City of Albuquerque

November 7, 2002

Re: Vittoria at Ventana Ranch (Tract J) Drainage Report
Engineer's Stamp dated 10-4-02, (B10/D3F)

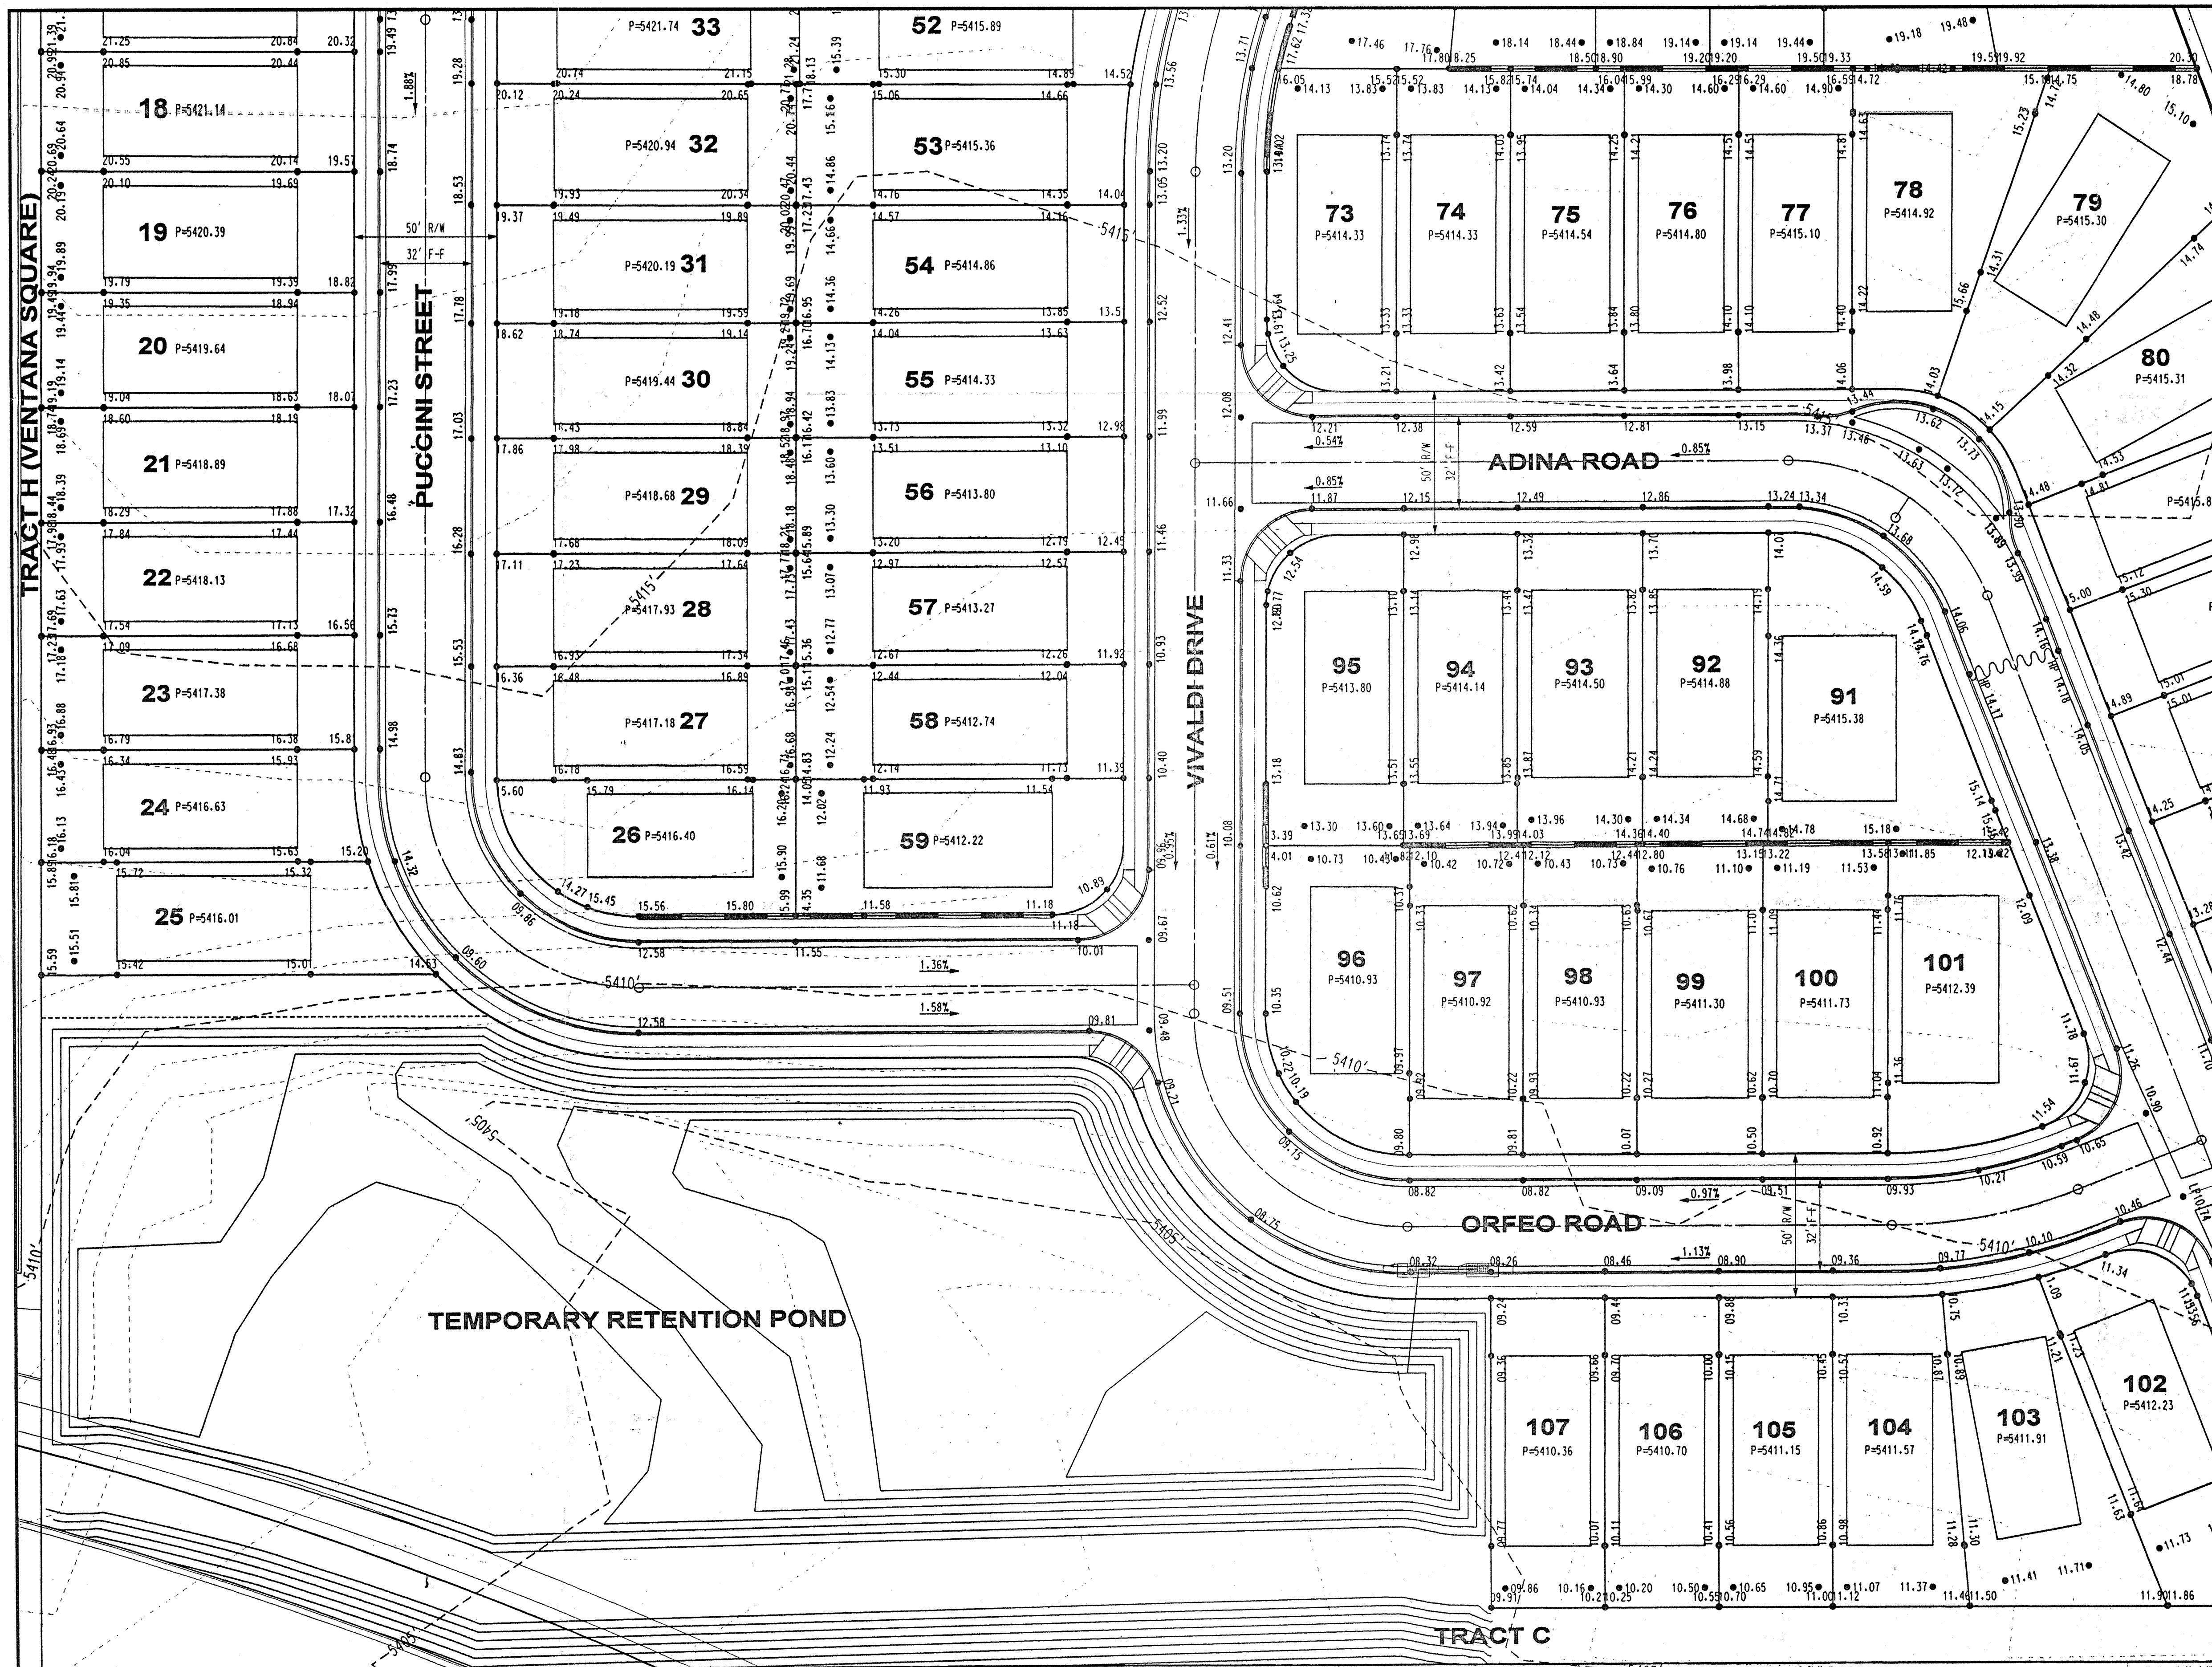
- Please modify the grading plan to include future grades of Paseo del Norte in order to verify that the pond may be able to be removed or drain to a storm drain in the future PDN R/W.
- Add enough conceptual master planning for Paseo del Norte (to the Piedras Marcadas outfall) to determine runoff amounts and critical analysis points for future development downstream.
